Our Ref: M/70/17/HH

**Town & Country Planning Act 1990 (as amended)
Town & country Planning (Development Management Procedure) (England) Order 2015
Application for Planning Permission for Works or Extension to a Dwelling**

Development Two storey side extension & loft conversion.

Location 10 Norfolk Way Elmer

ELEVATION FACING WEST

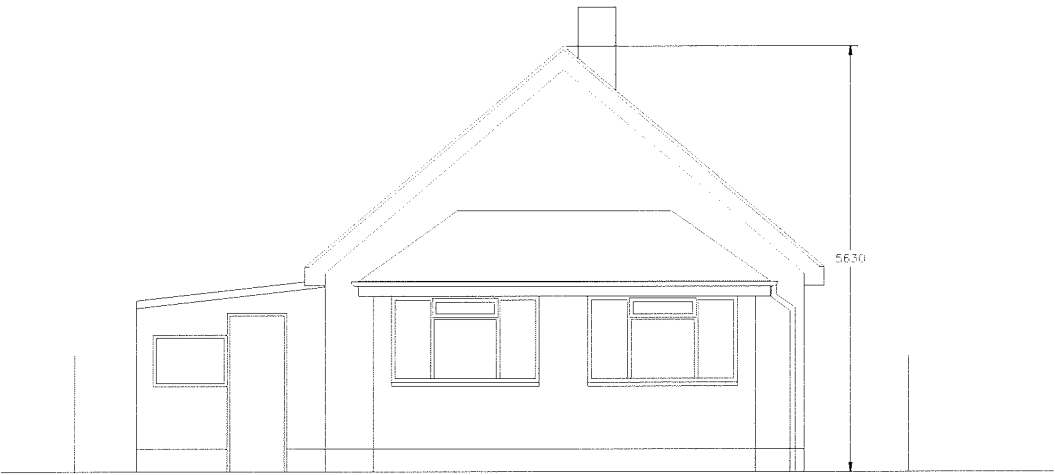
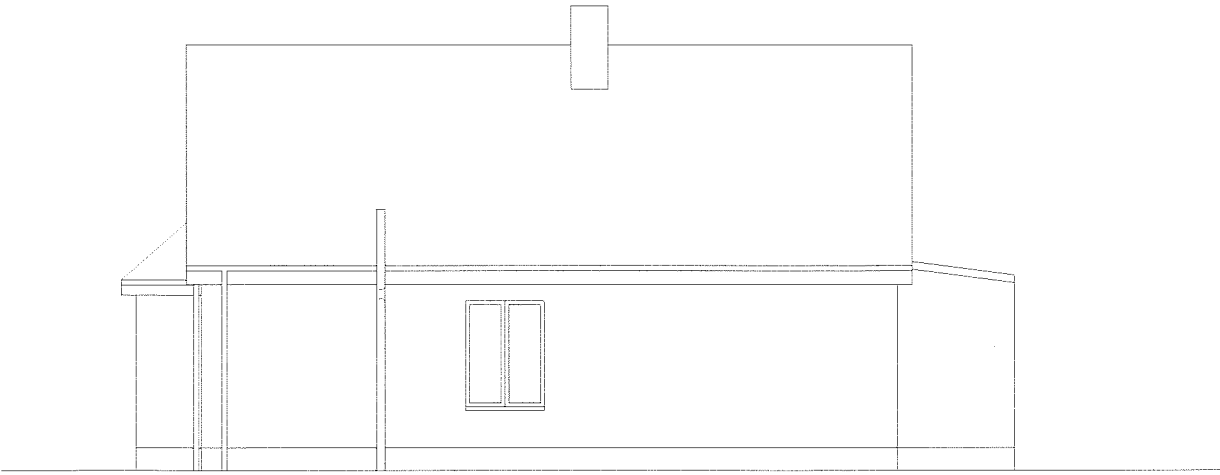
Please confirm if you wish the new window on the ground floor West elevation included in the description.

SITE BLOCK PLAN 1:500
OS TILE LICENSE NUMBER: 100022432

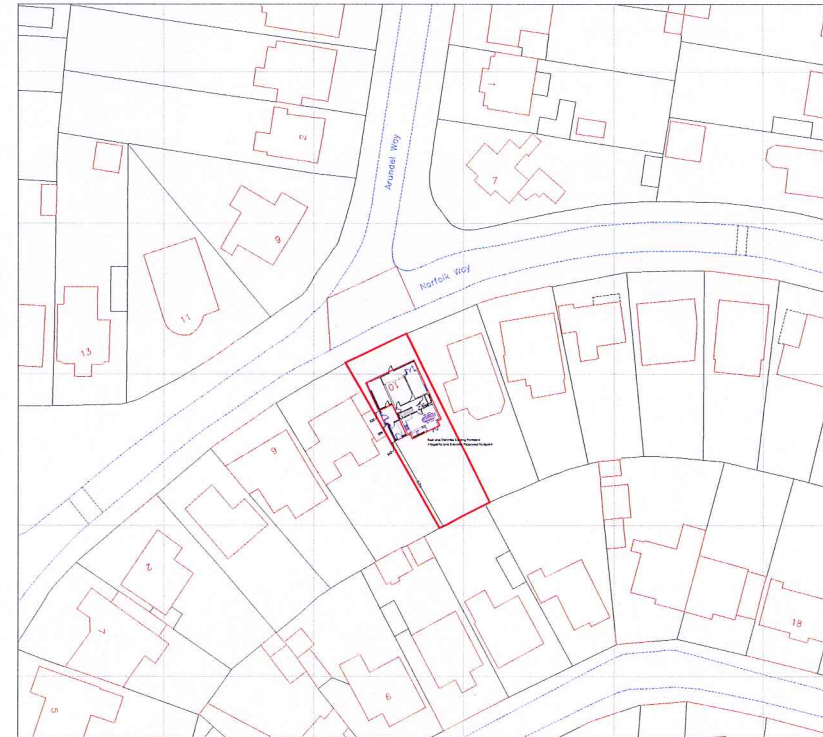
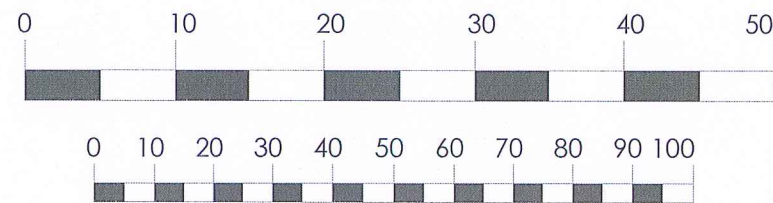
On the existing and proposed Location plans, please provide one named road.

On the proposed block plan, please highlight the proposed works and provide measurements from the proposal to the site boundaries.
